RE: 7-Eleven
1360 NC 24-87
Cameron, NC 28326

This letter acknowledges review of plans for the remodel of the above referenced establishment. The original plans dated 06/06/25, revised application, and specifications, including email correspondence are conditionally approved with the following comments:

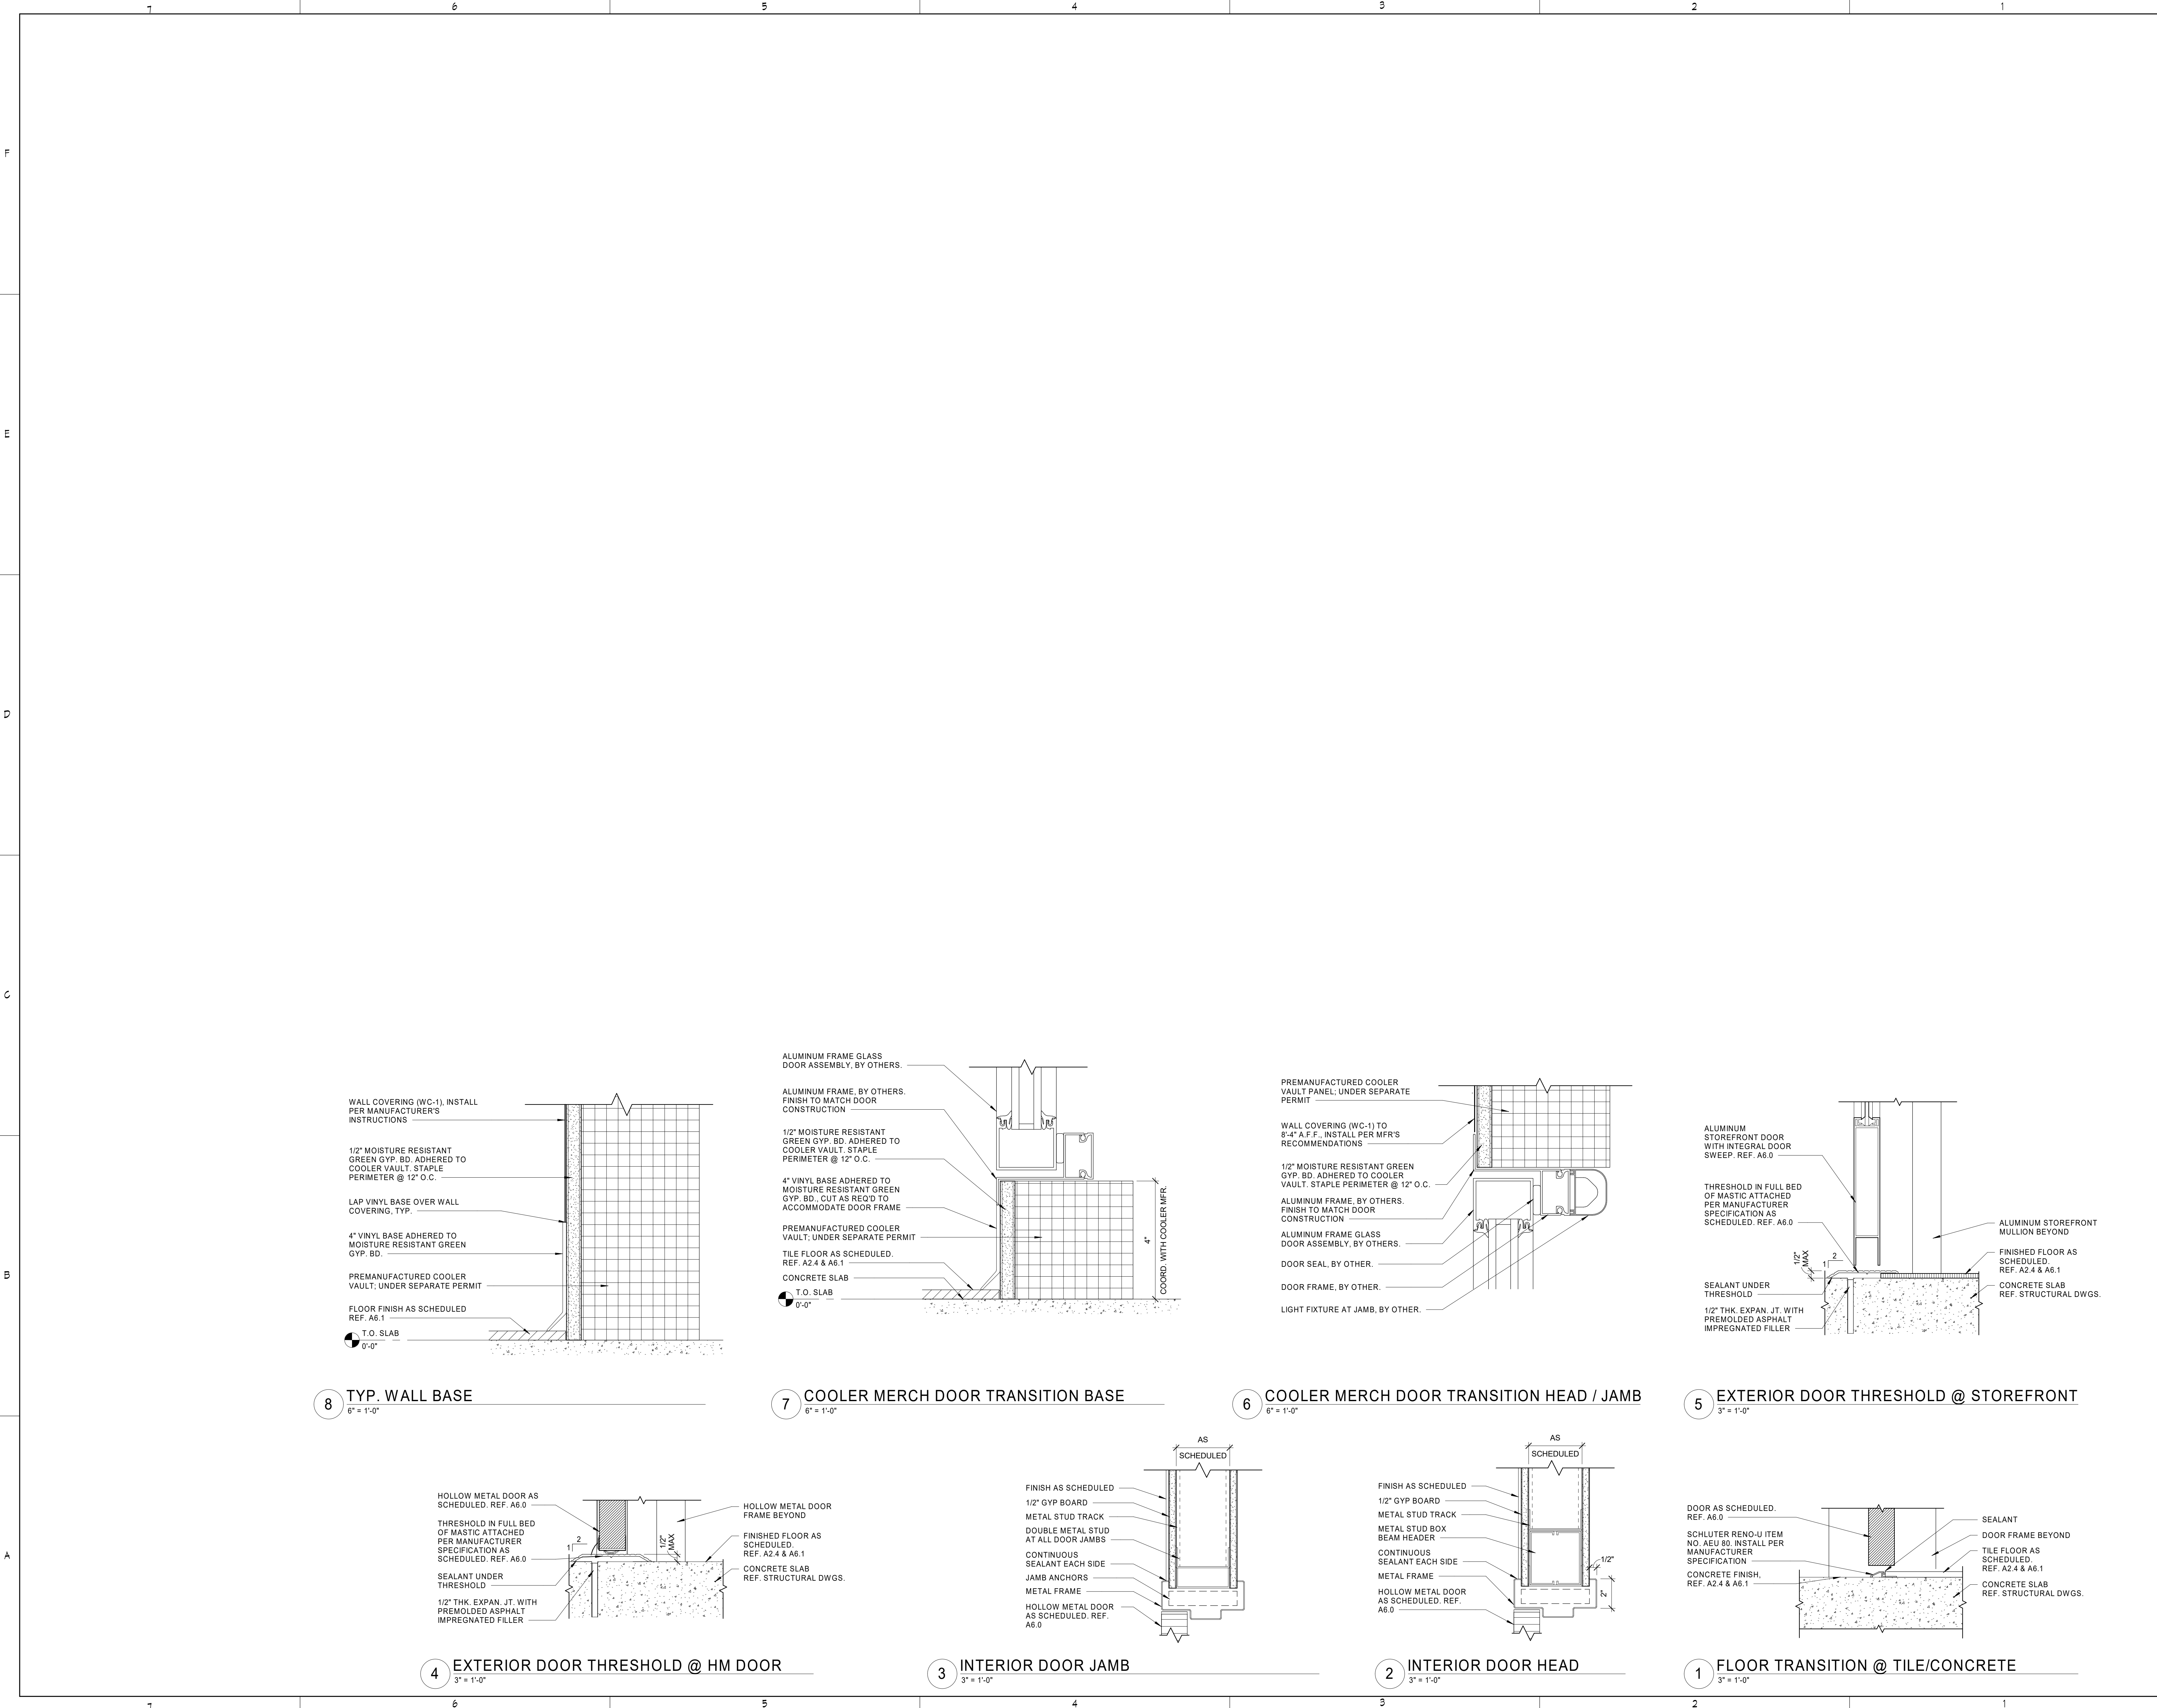
3. The finishes as specified on sheet A6.1; Materials Schedules, and on the application must comply with Subparts 6-101 and 6-201 of the Food Code. New finishes must be smooth, durable, and easily cleanable for areas where food establishment operations occur. In addition, the wall and floor junctures in all food service areas, walk-in coolers/freezers and in the toilet room areas must be coved.

P1.0

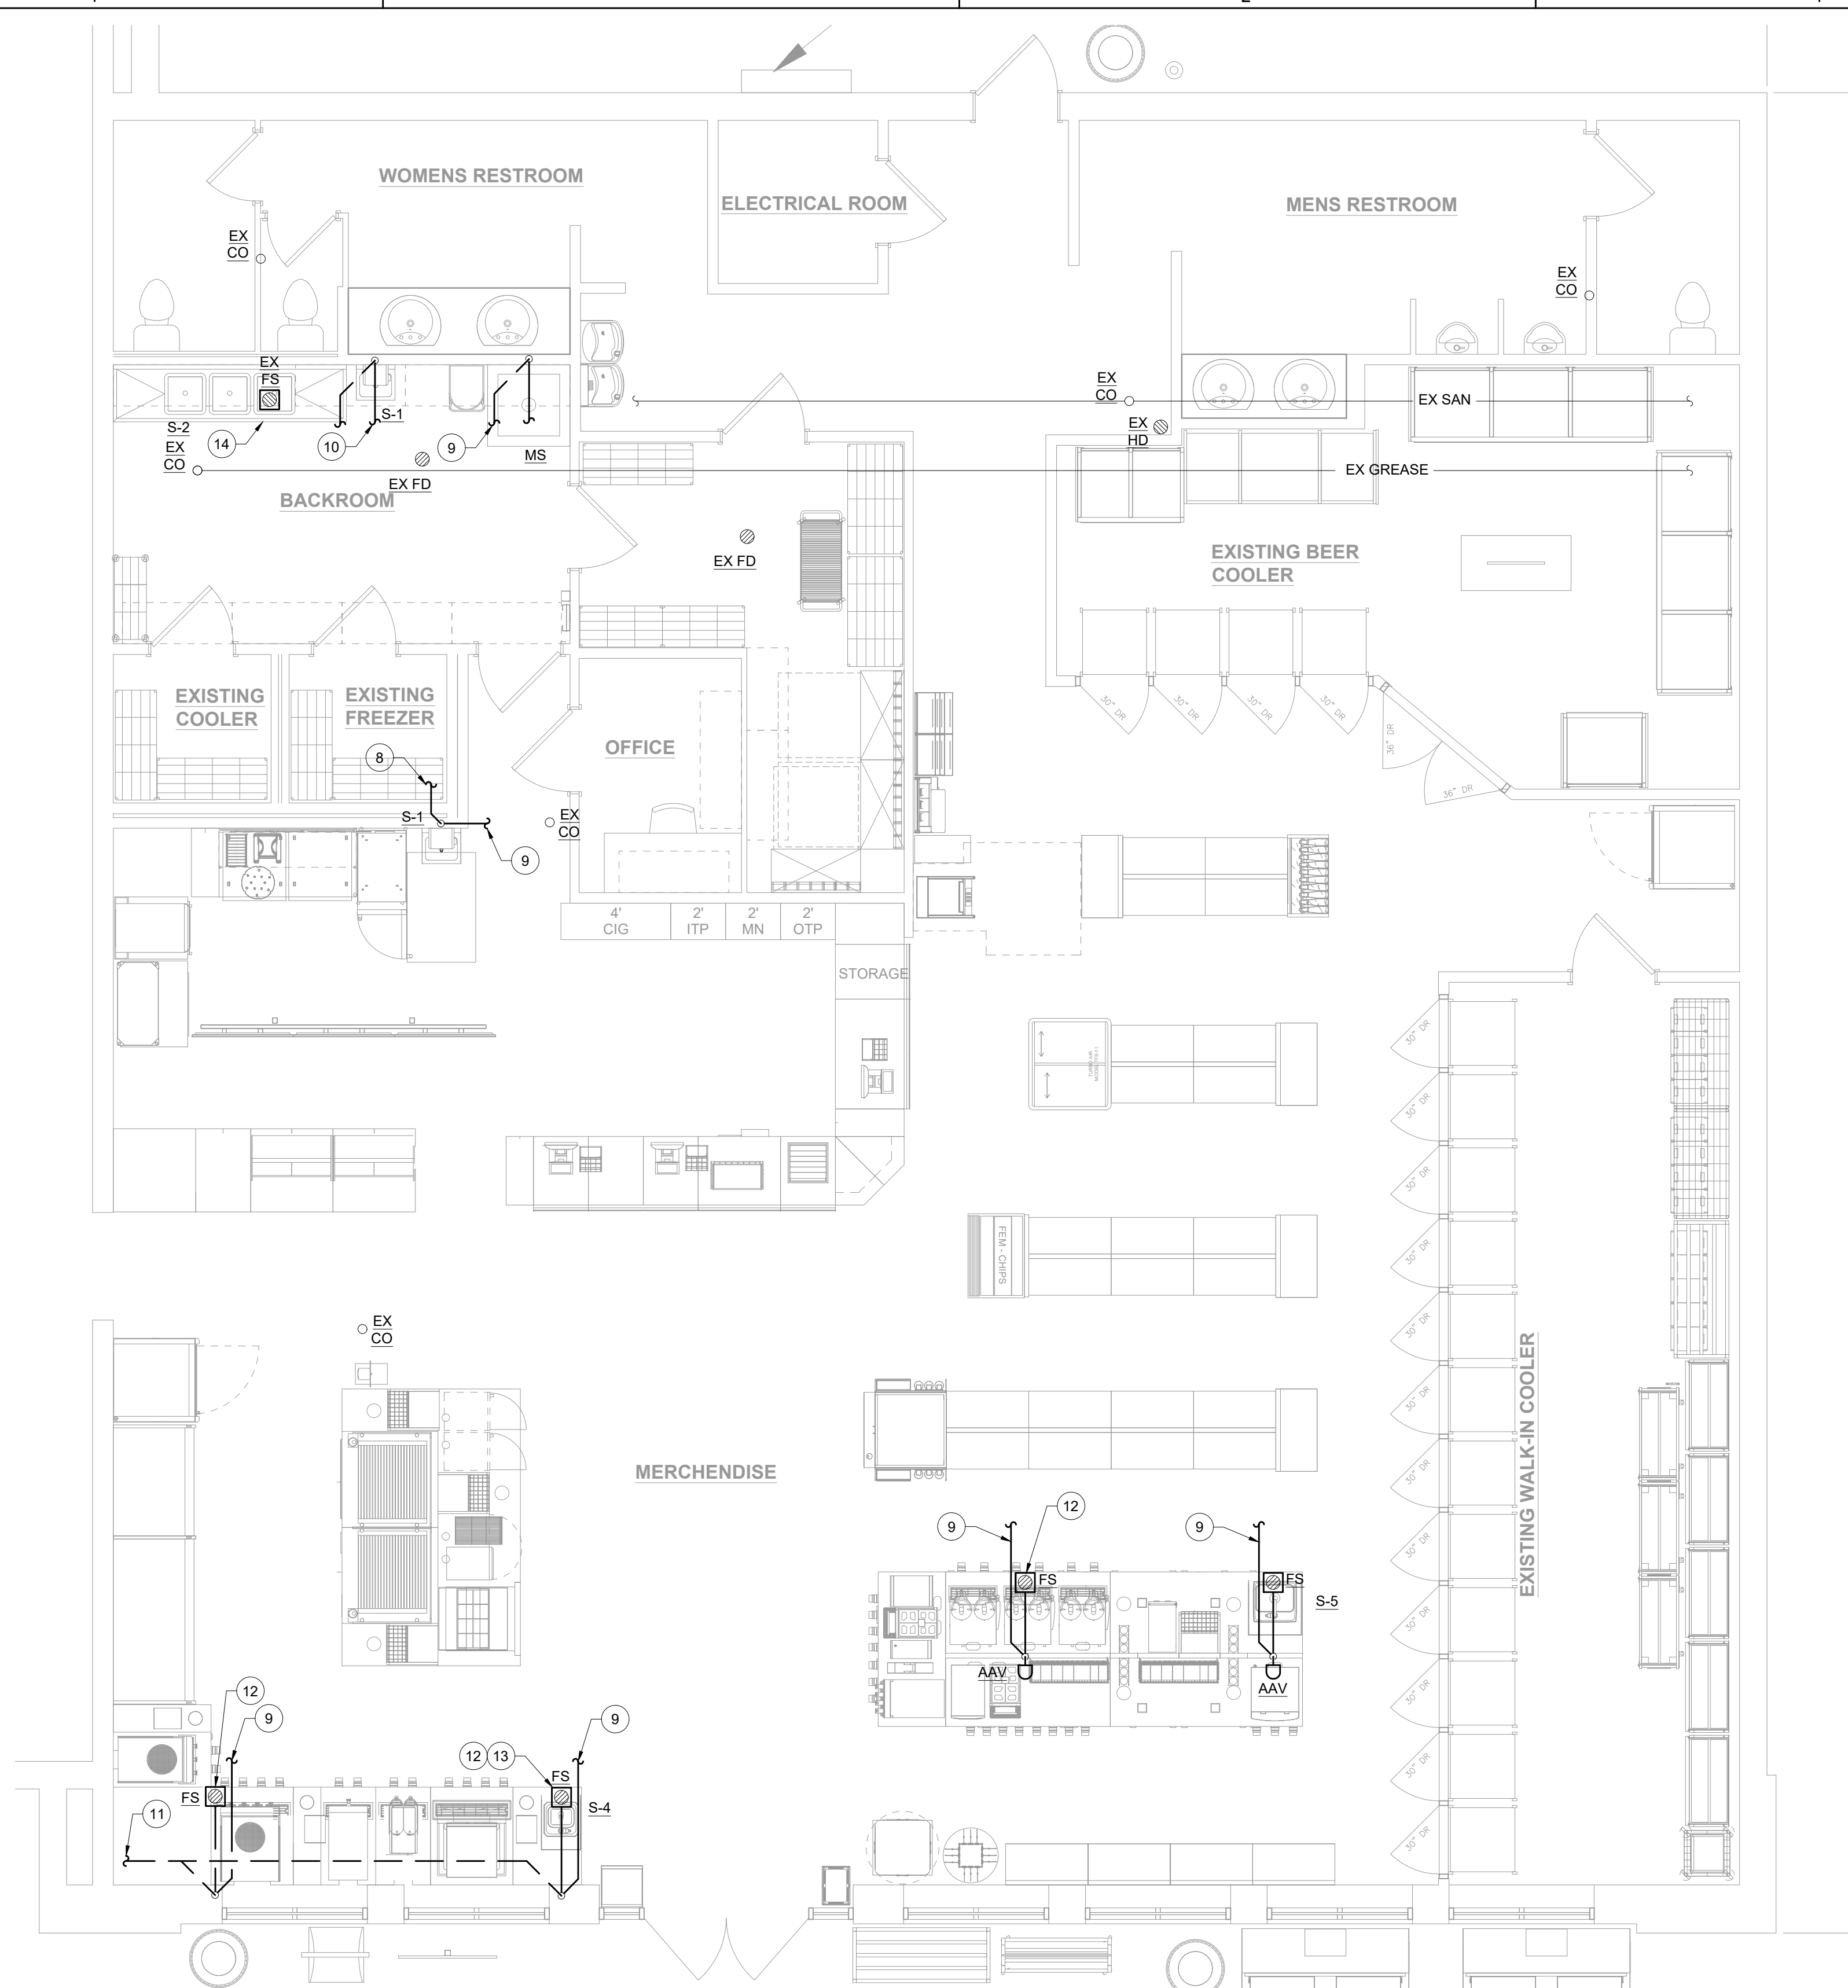
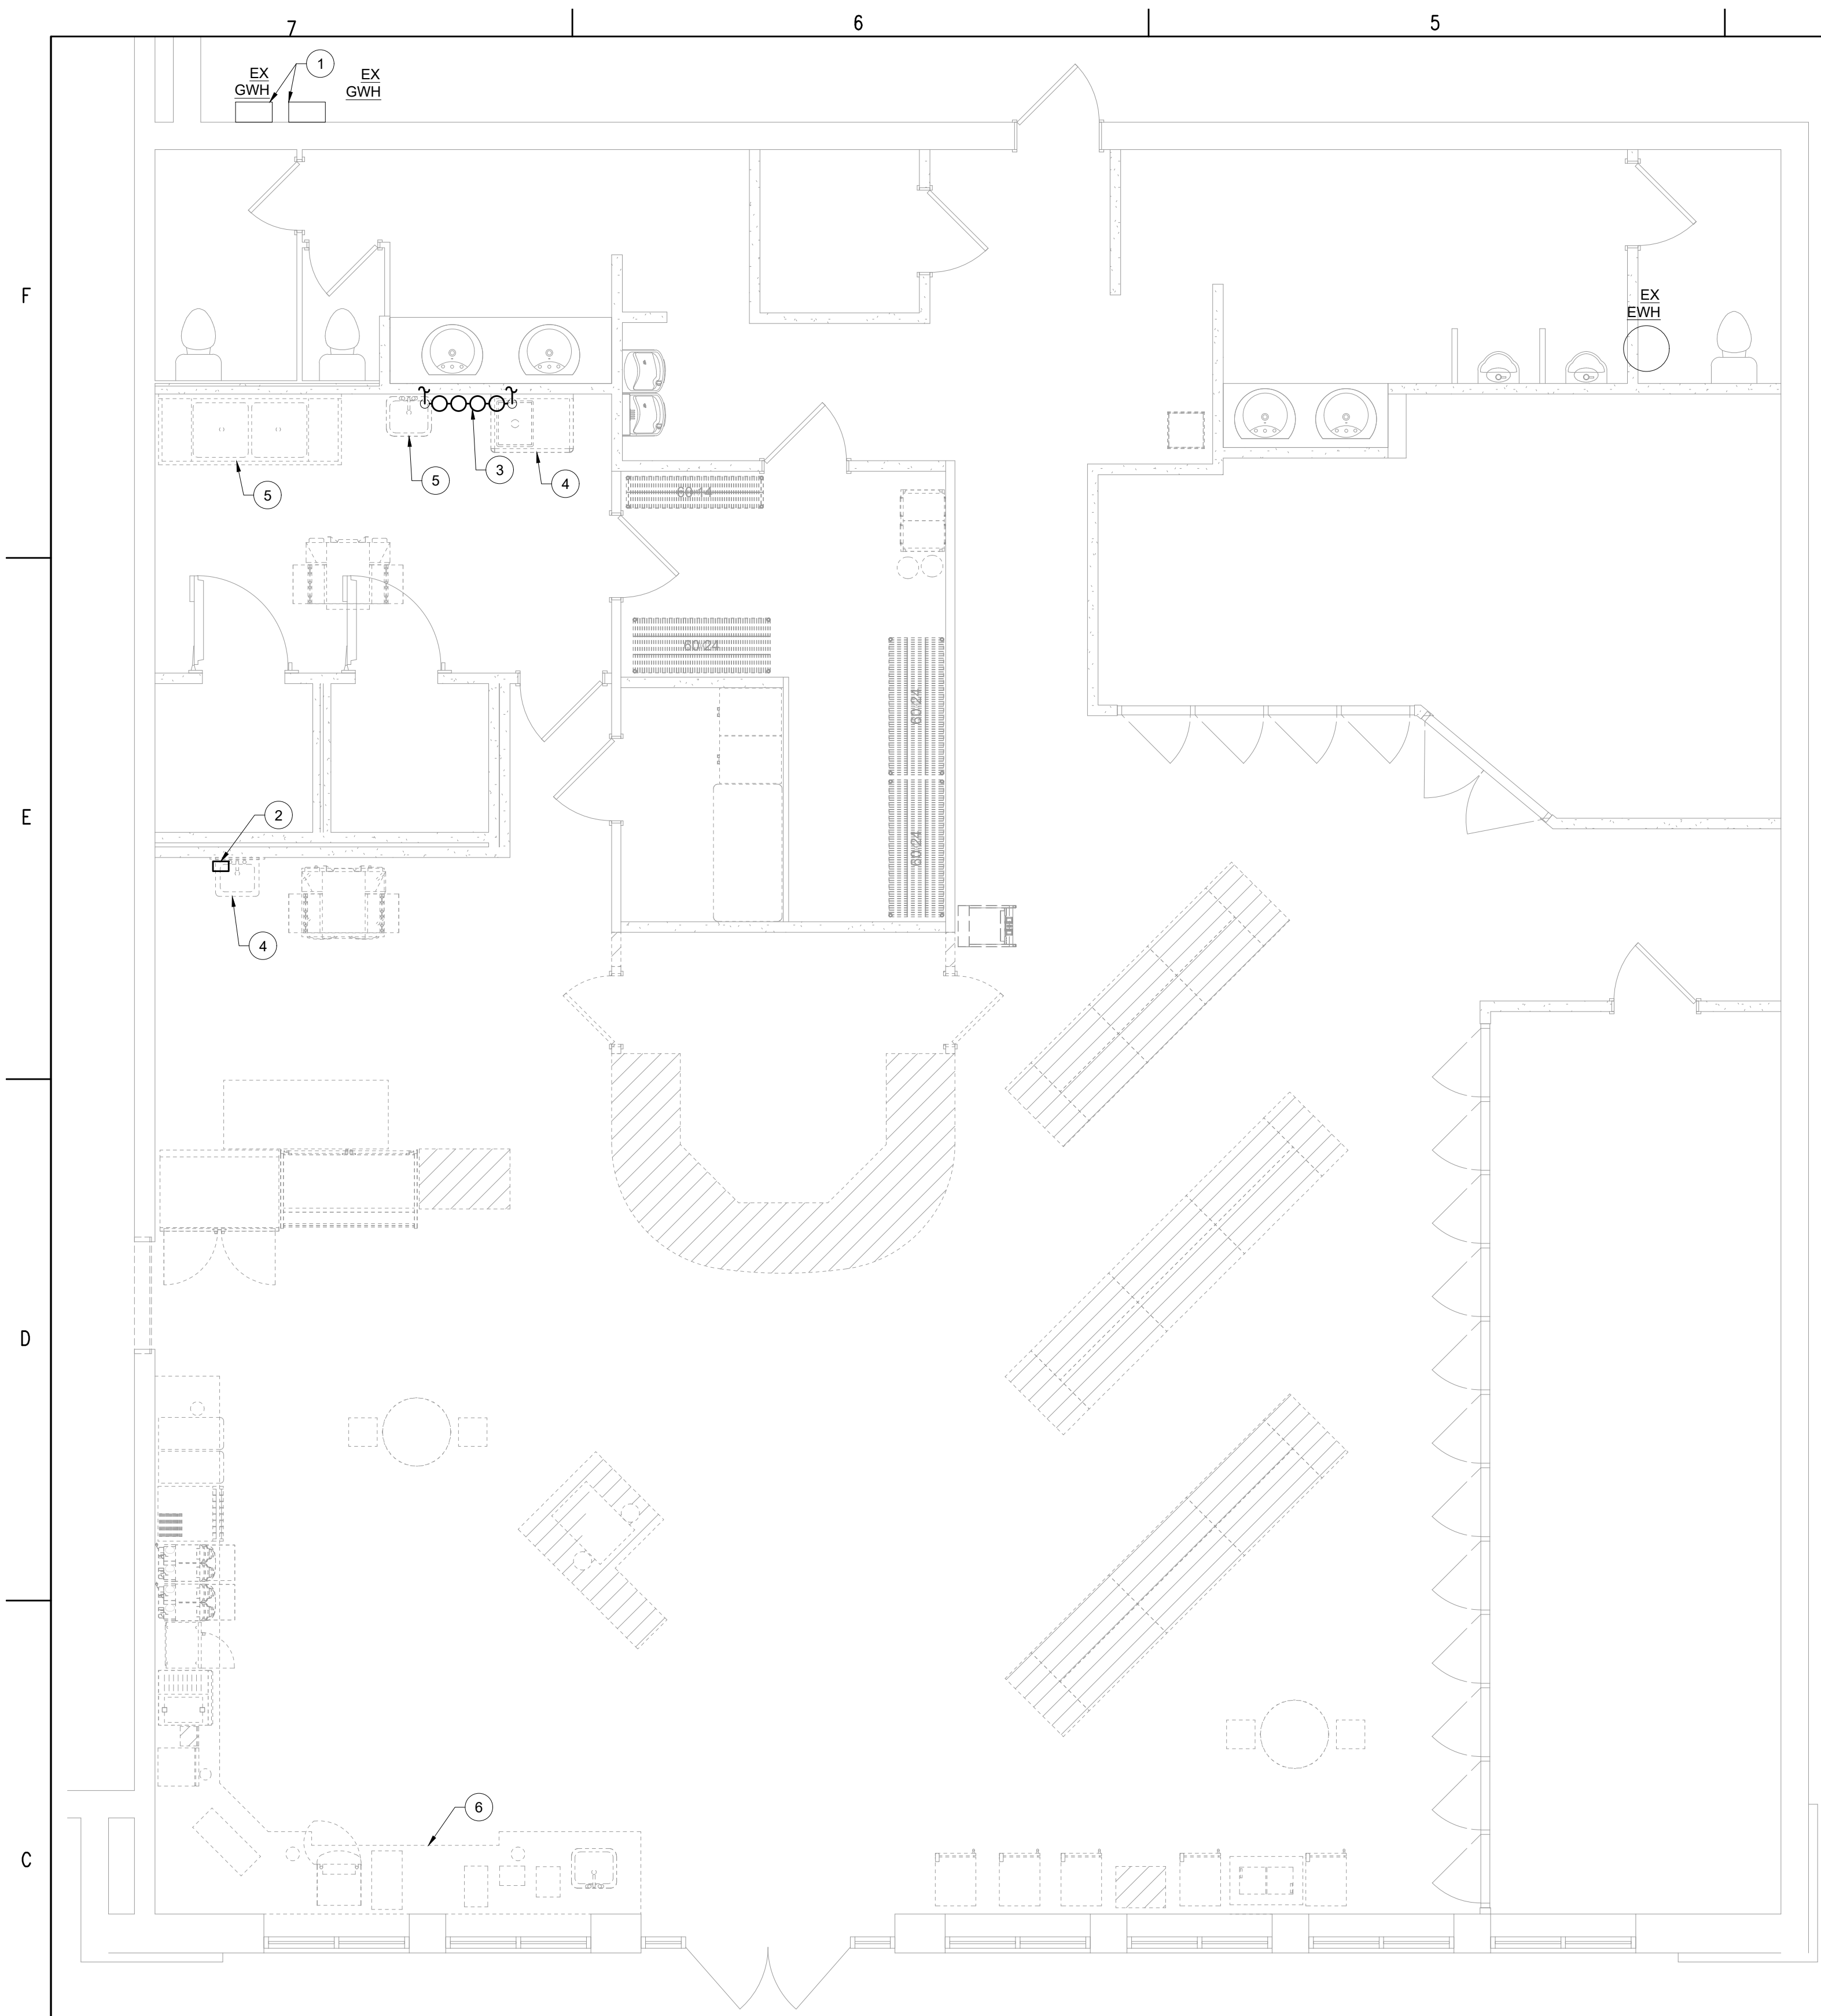
4. Plumbing must comply with all applicable plumbing regulations. These shall comply with Parts 5-1 and 5-2 and Parts 6-3, 6-4, and 6-5 of the Food Code. The Drain Piping Plan on sheet P1.0; Domestic Water Piping Plan on sheet P1.1, and P2.0; Plumbing Details and Schedules plan sheet are conditionally approved with the (2) 199MBH tankless water heaters as noted on sheet P2.0, and on the revised application. It is understood with the acceptance of engineered sealed drawings, if the design of
